SLAF
C/O Suffolk Highways

Date: 30 September 2020

Representation to the Planning Inspectorate by the Suffolk Local Access Forum in response to the Development Consent Order by NNB Generation Company (SZC) for the proposed Sizewell C Nuclear Power Station. Planning Inspectorate Reference: EN010012

DRAWING TITLE:
 SUFFOLK COAST PATH AND FUTURE ENGLAND COAST PATH DIVERSIONS - CONSTRUCTION PHASE

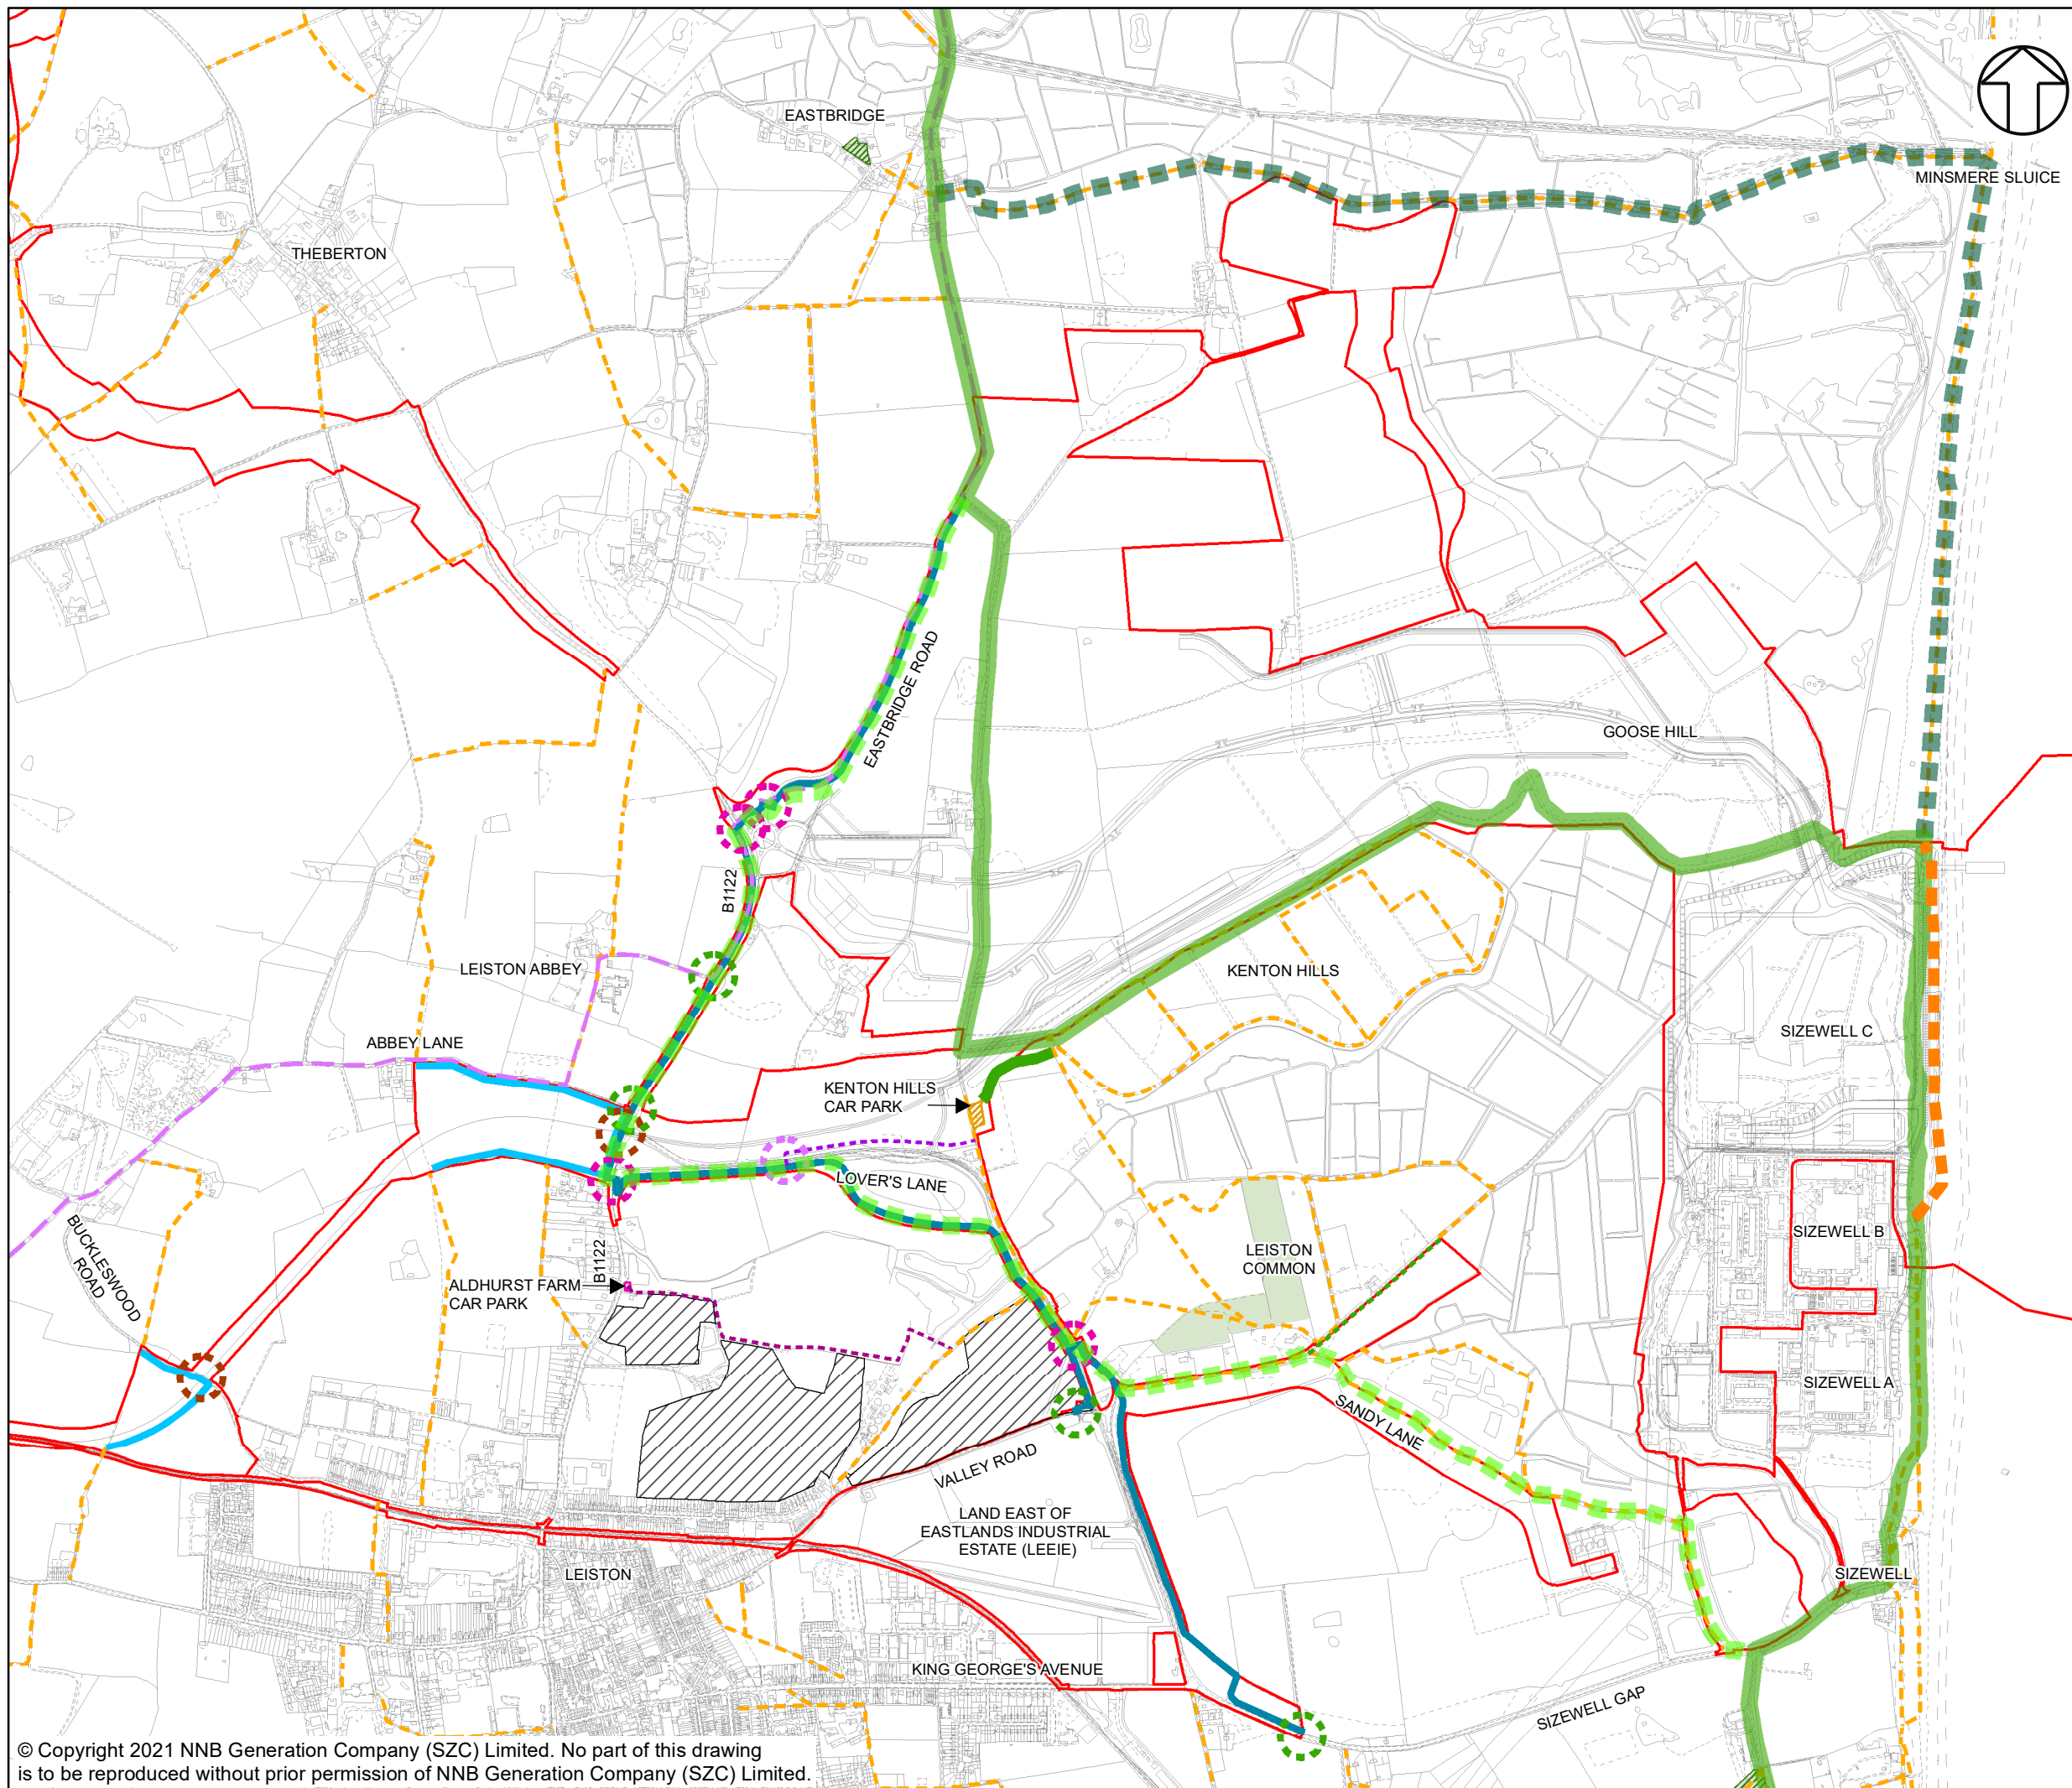
What is now the Suffolk Coast Path will shortly become part of the England Coast Path. Regrettably the route suggested by EDF is along soft sea defences which over time could disappear with coastal erosion. SLAF therefore requests that the definitive route of the path is moved onto the top of the new hard sea defences being constructed to protect the new power station.

During the construction of the proposed new sea defences we would expect the Coast Path to remain open. In the longer term we have concerns that the path being squeezed between the new dunes and the beach that if over time the beach erodes then the path could be lost when roll-back finally reaches the power station boundary.

We are especially concerned about the soon to be England Coast Path. As SLAF understands it, during the construction of the new sea defences in front of Sizewell C the path may be diverted down the beach towards the sea. This raises safety issues, for instance if there is a high spring tide. We would also expect any such diversion to be accessible to all users with matting or something similar laid over the shingle to provide a level surface. Once the sea defences are in place, we would like to see the definitive legal route of the public right of way moved to the top of the defences which should be of sufficient width to accommodate this. This would future-proof the route against any long-term erosion issues.

With the possibility of closures of the Coast Path to enable beach landing of construction materials, these should be kept as short as possible and the frequency and duration notified well in advance to all interested parties. SLAF is still concerned that proposed long diversion route could cause problems to people who are walking to a tight schedule and the extra time taken for that this route could cause them accommodation problems at the end of the day. We therefore would see the provision of a shuttle minibus between Sizewell and Dunwich as an alternative of great benefit.
